Subject: BN/50/18/PL The Fallows

I am just looking at your application BN/50/18/PL. I think the current plans, descriptions are not clear and I would like to change the description to say: "Erection of 1 No. replacement dwelling and conversion of existing outbuilding (approved dwelling) into double garage".

| CLIENT | PROJECT                | TITLE                                                               | STATUS   | DRAWN BY   | REVIEWED BY    |
|--------|------------------------|---------------------------------------------------------------------|----------|------------|----------------|
| D KEET | MEADOW VIEW<br>BARNHAM | PROPOSED PD<br>EXTENSIONS<br>- PROPOSED FLOOR<br>PLANS & ELEVATIONS | PLANNING | SJ         | SJ             |

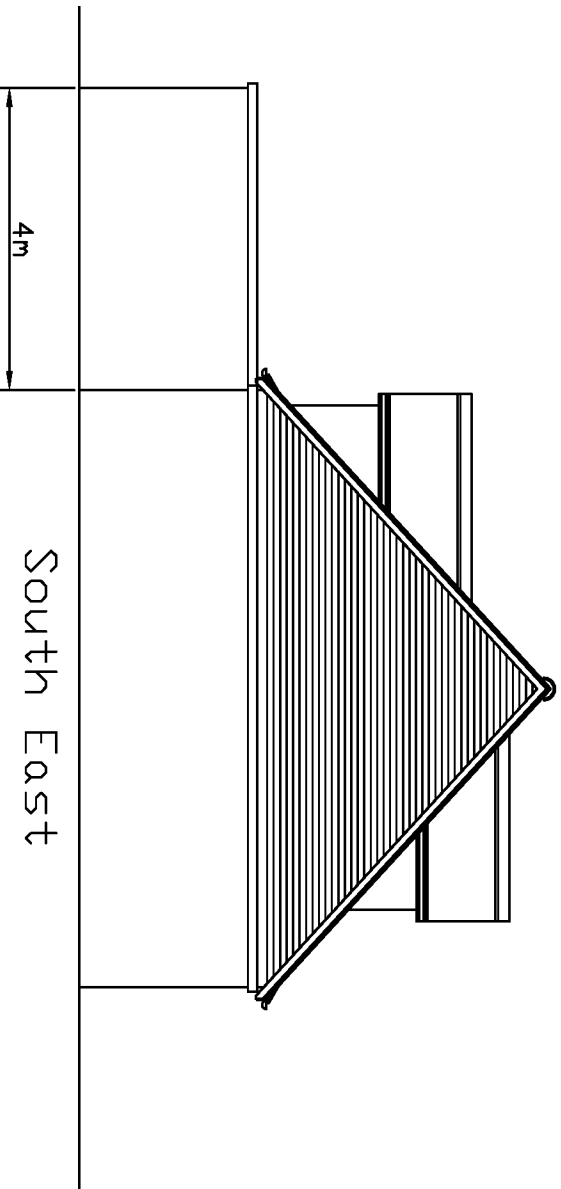
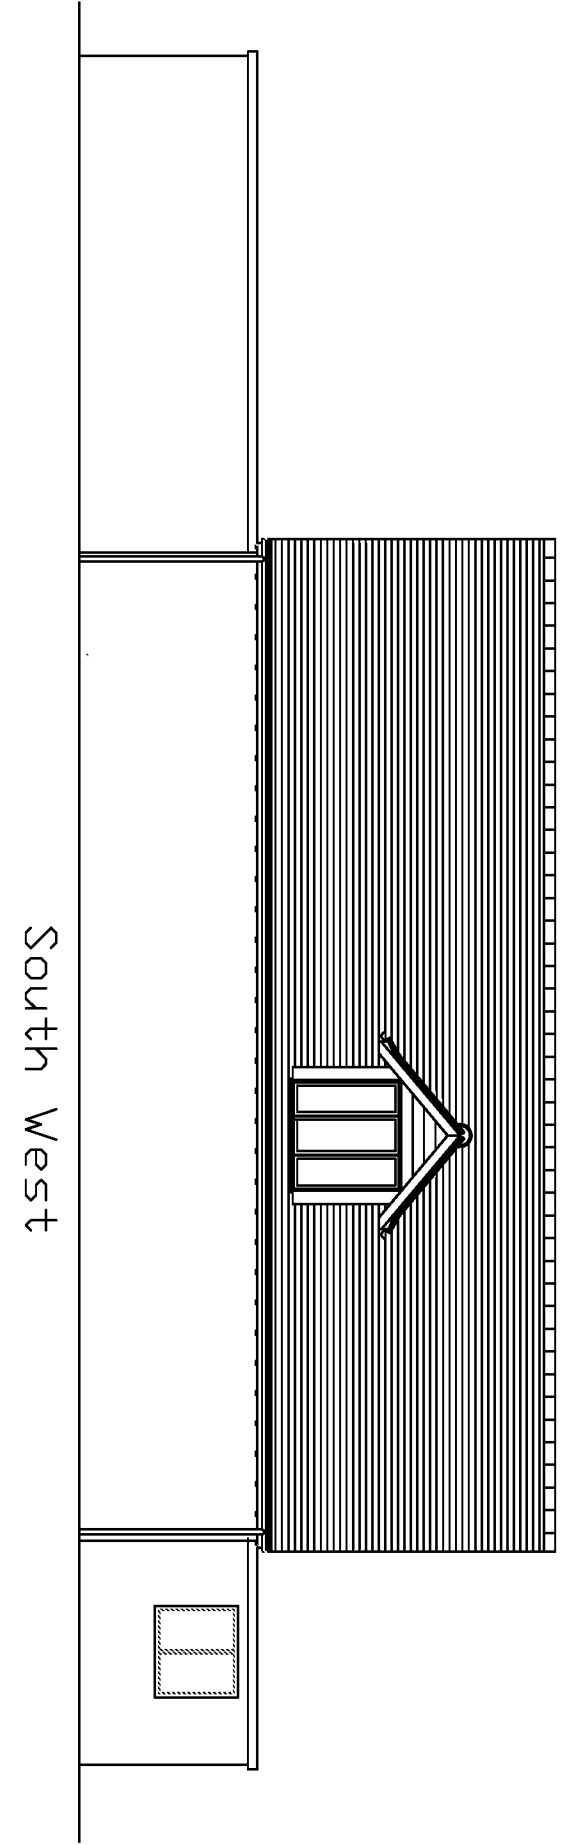
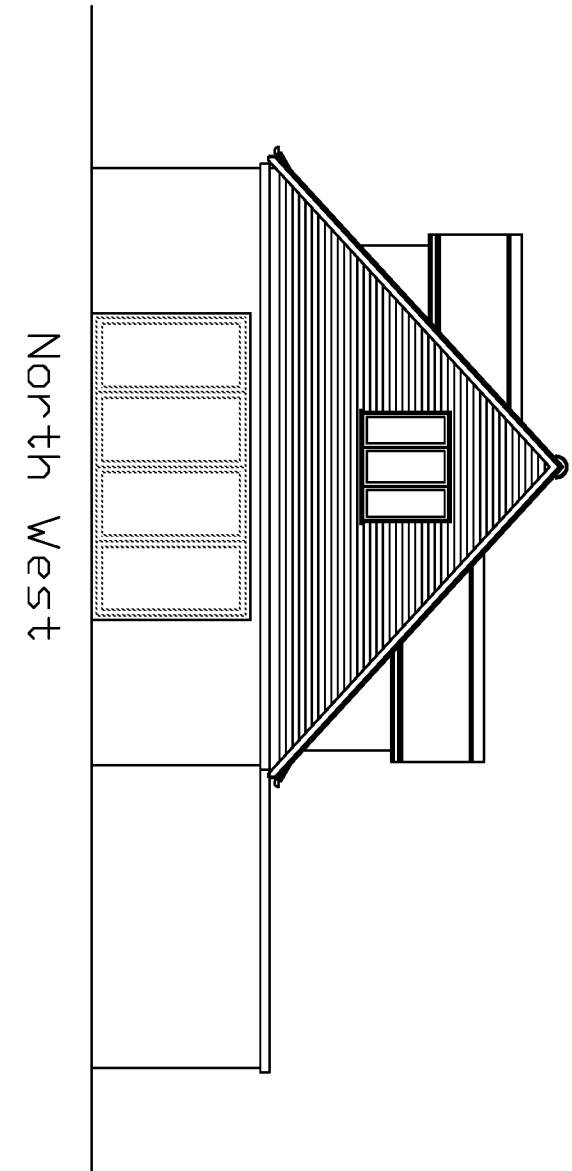
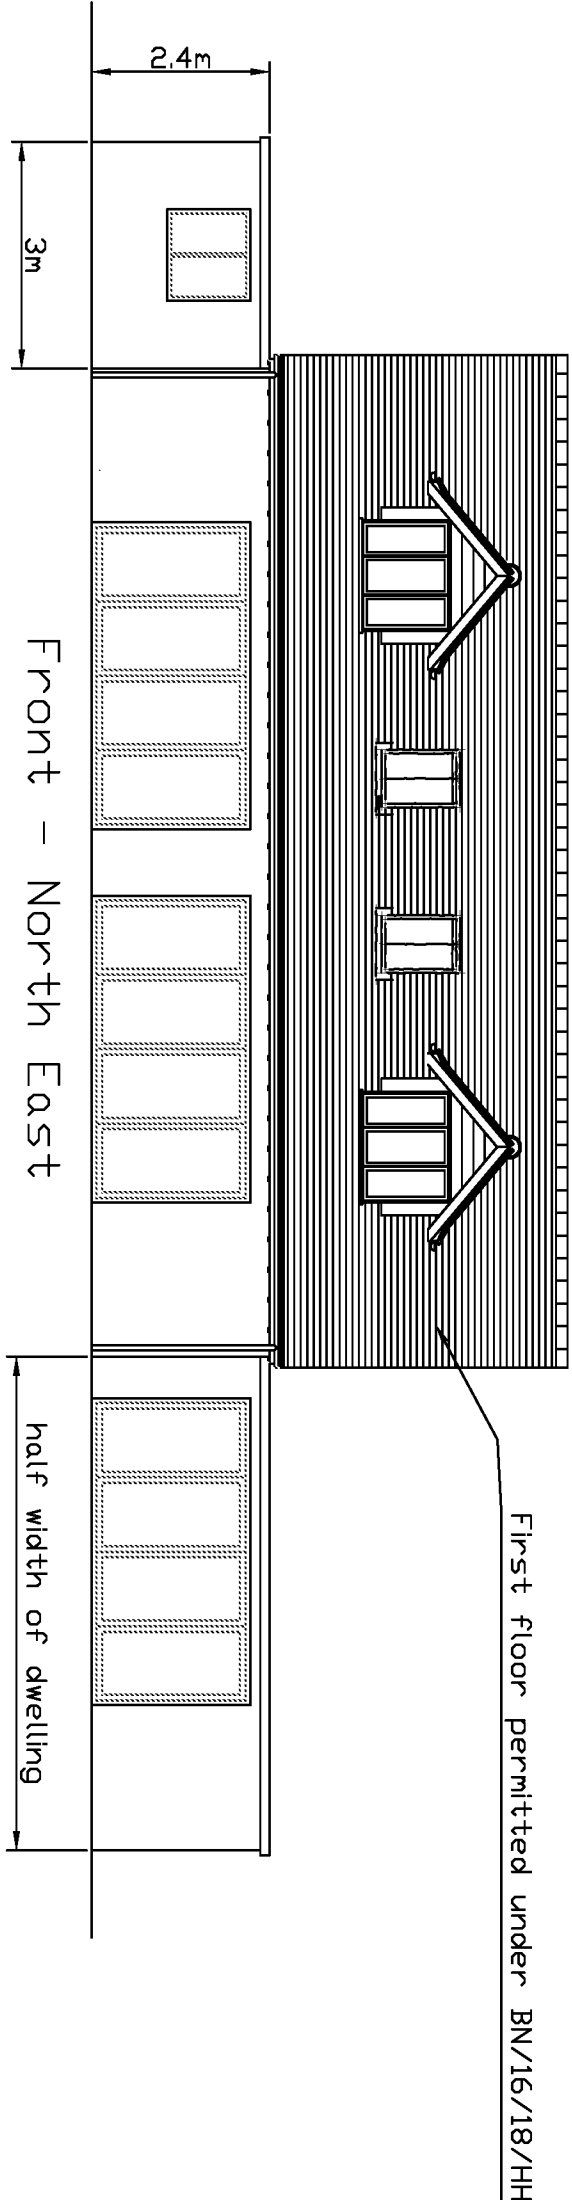
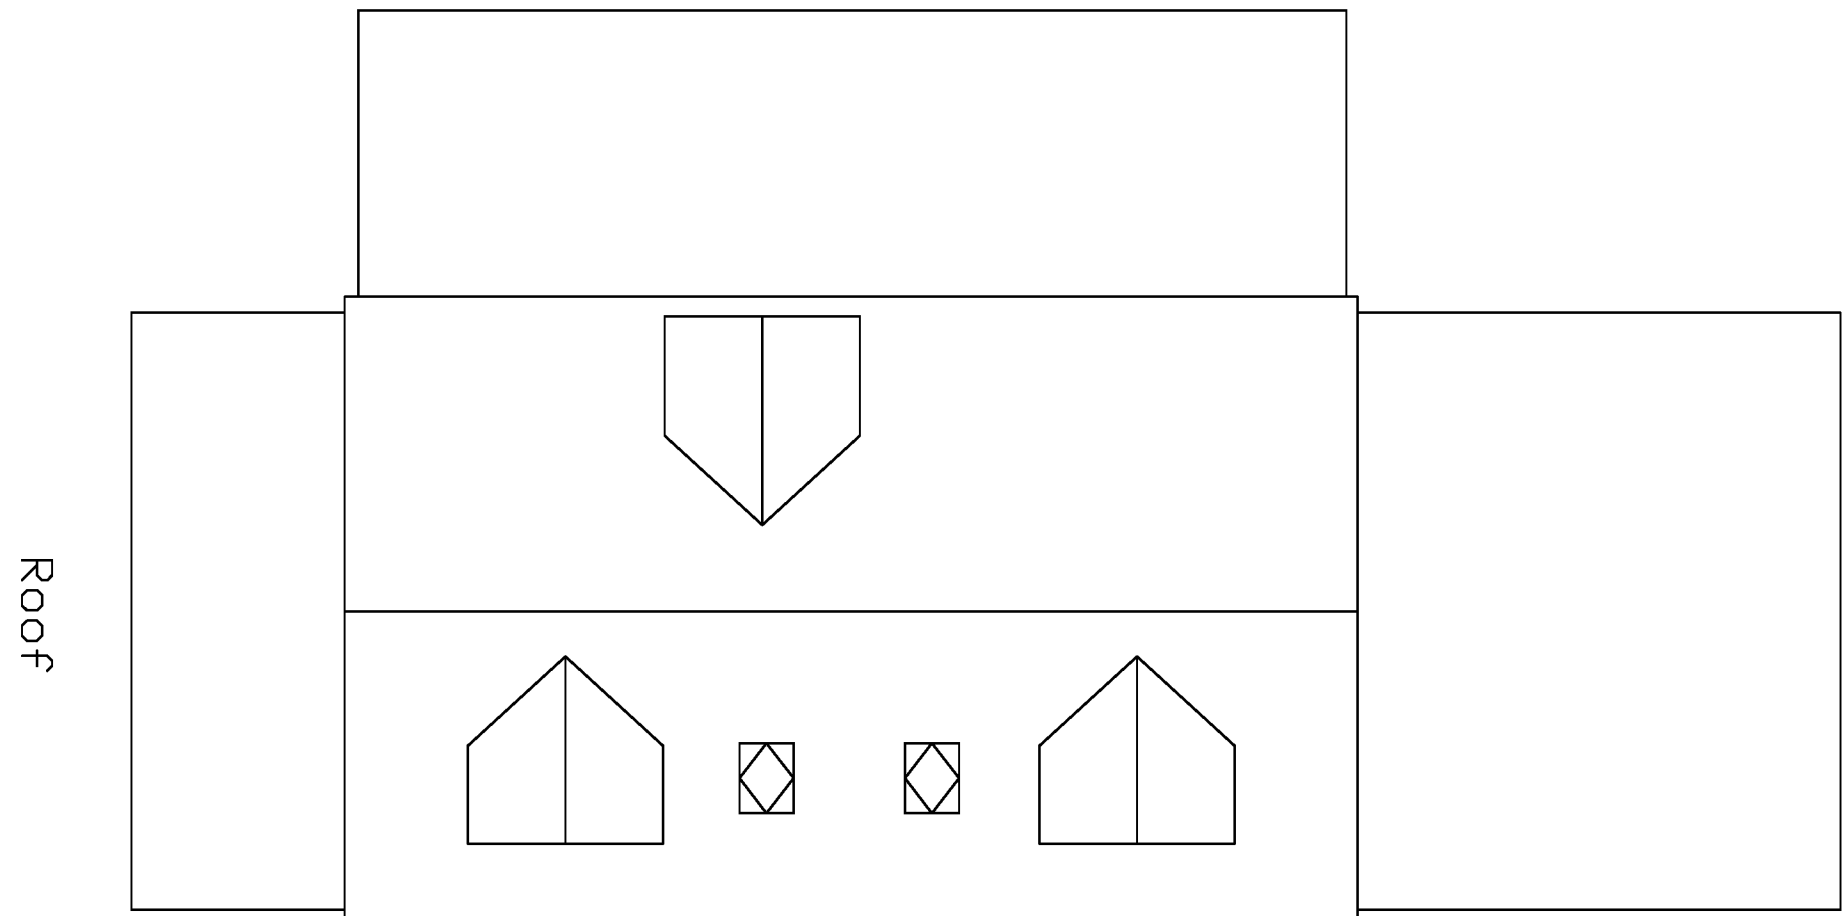
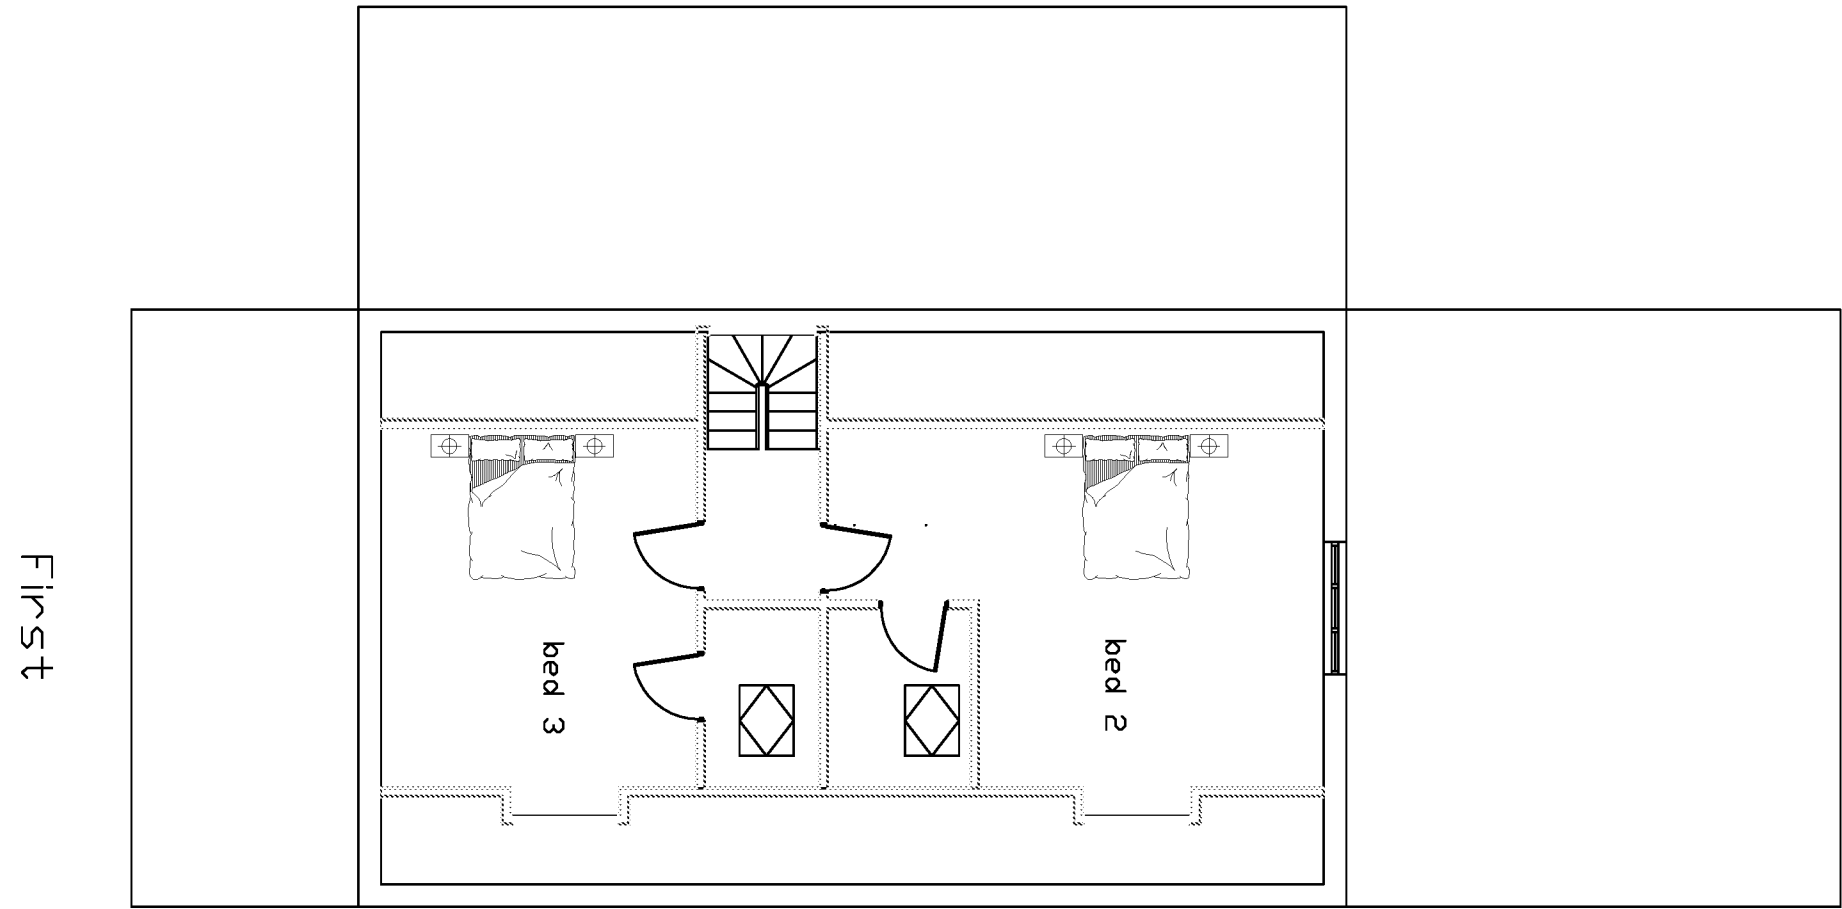
Can you also withdraw Dwg 16 "Permitted Floors, Roof & Elevations plans" as this is not relevant to what you now want to do. Please can you then amend the Dwg 3 "Proposed Site Plan" to remove the references to the permitted extensions to the outbuilding and just show the outbuilding as the garage that you are proposing.

Drawing 3 - Proposed Site Plan
Scale 1:500 @ A1

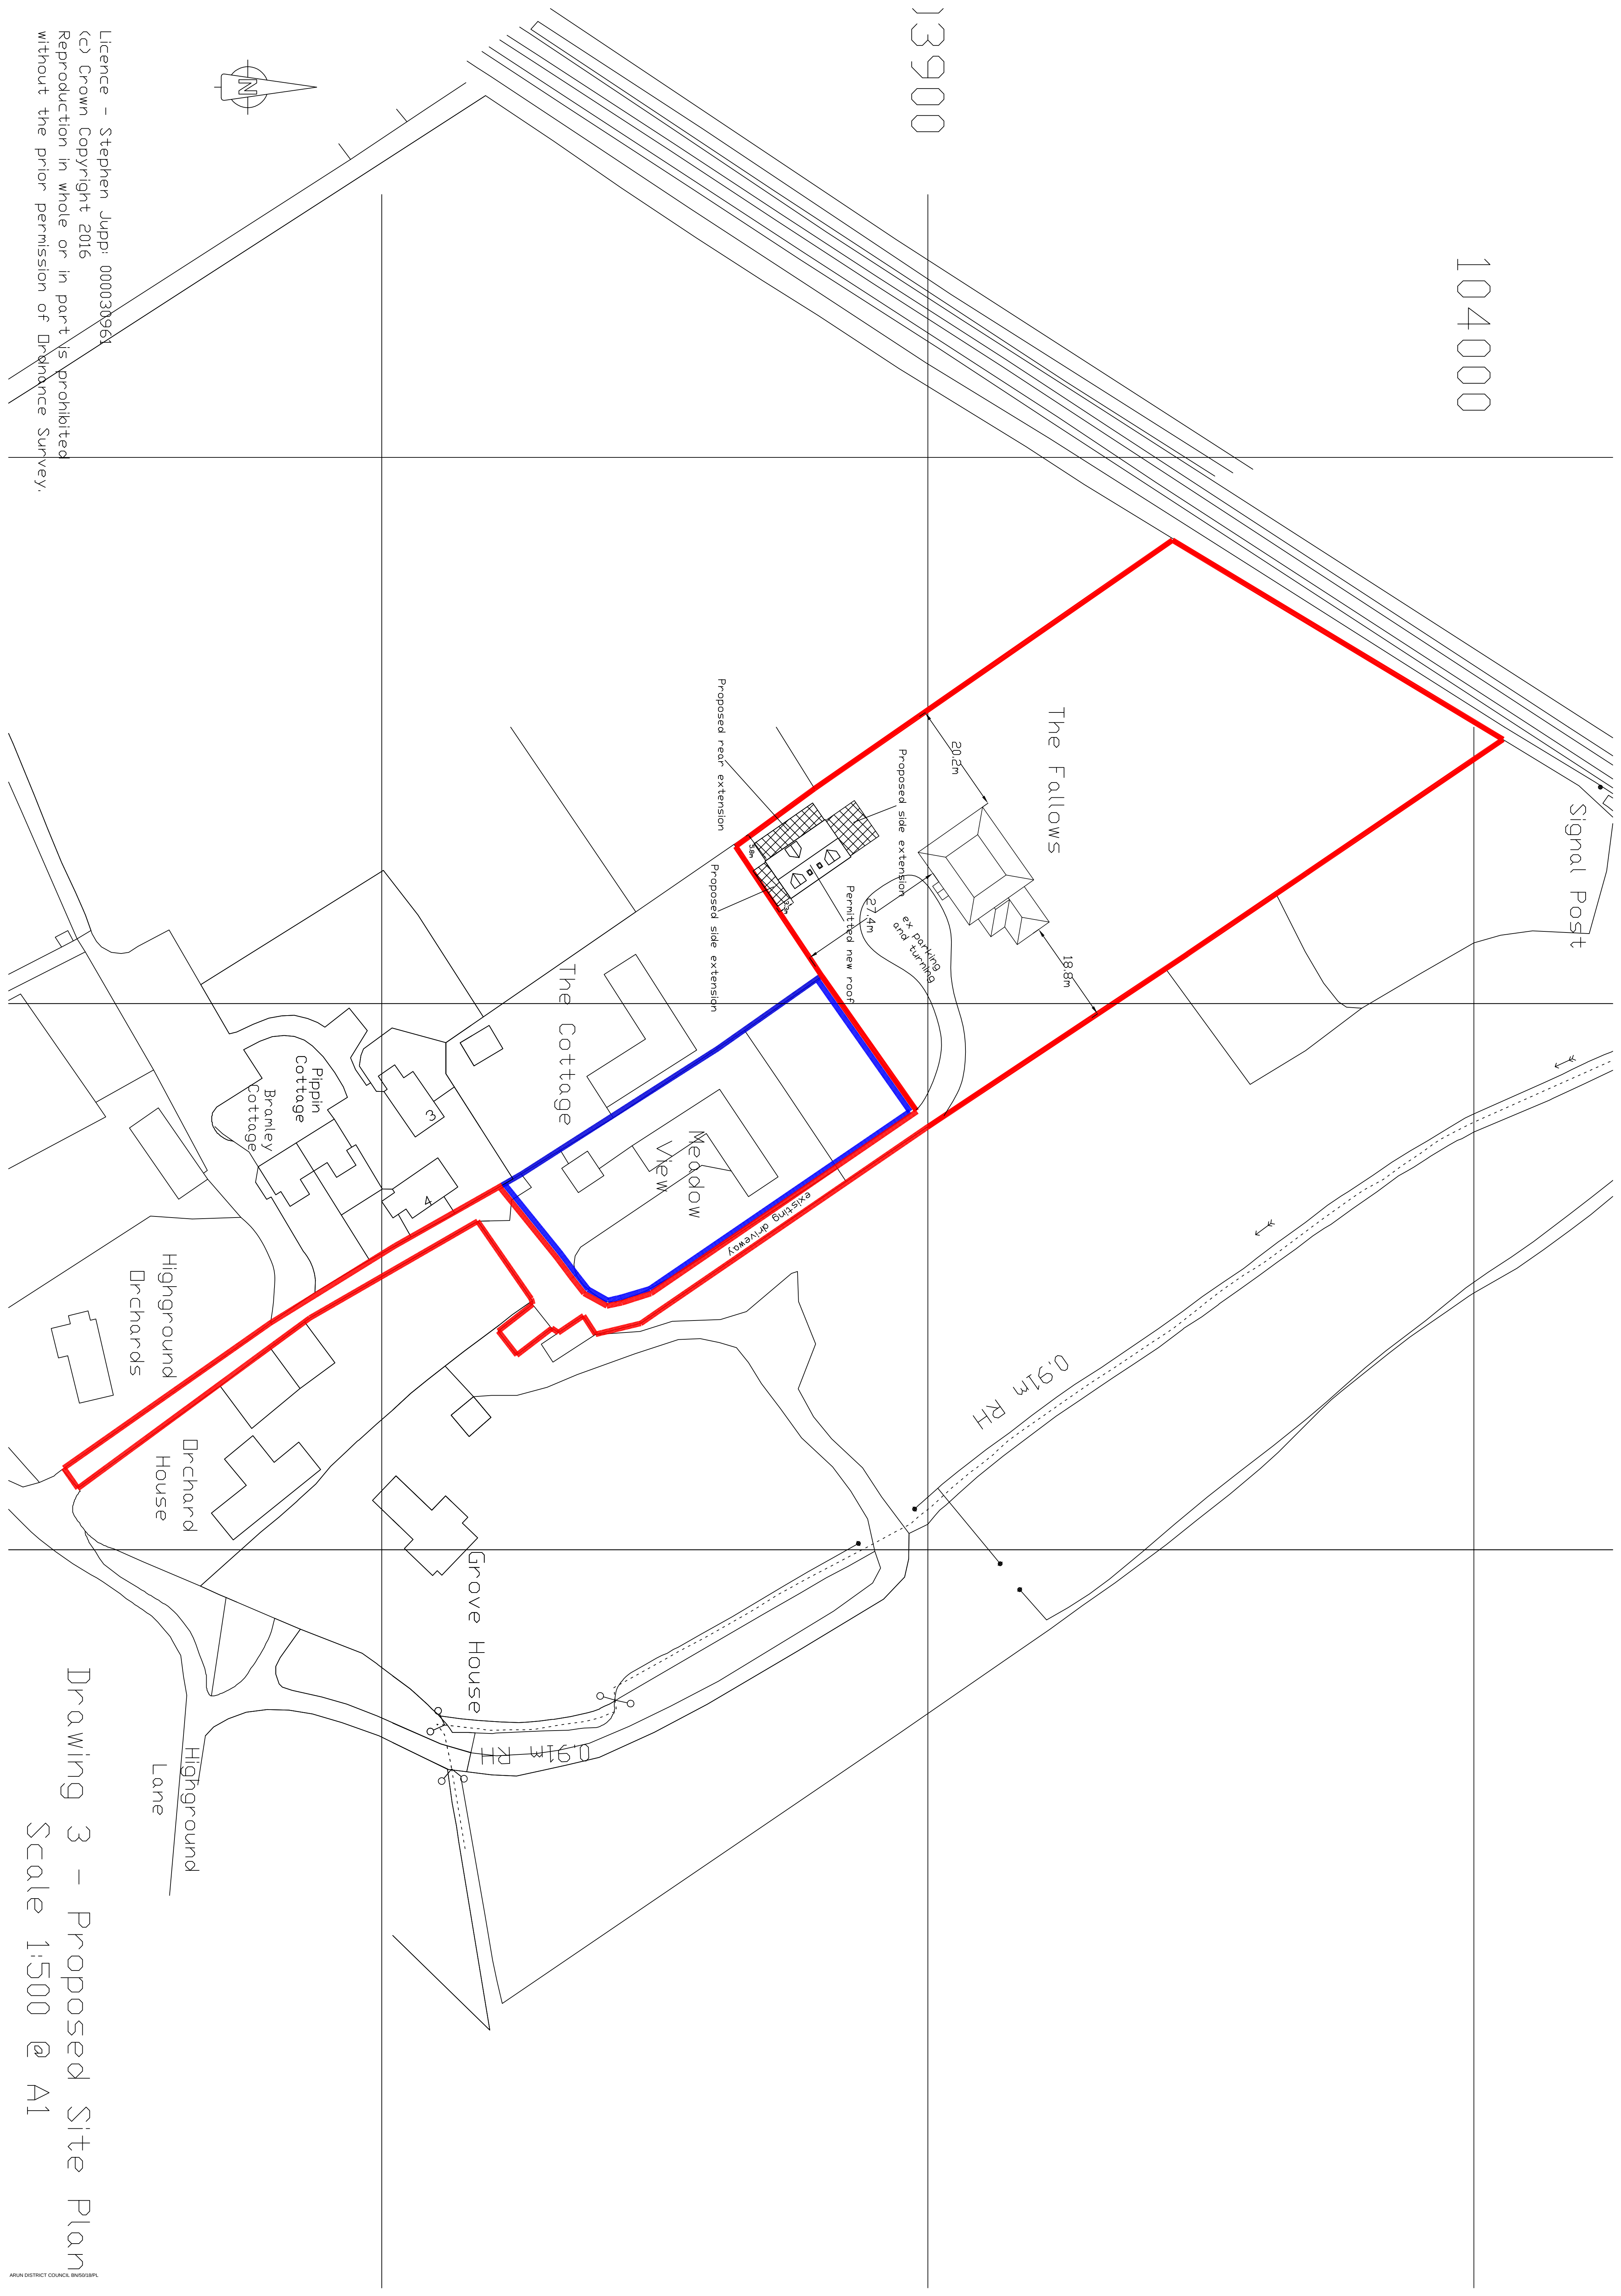
My concern is that someone will look at this and not read the planning statement and think that you are proposing one large house and also domestic extensions to the outbuilding.
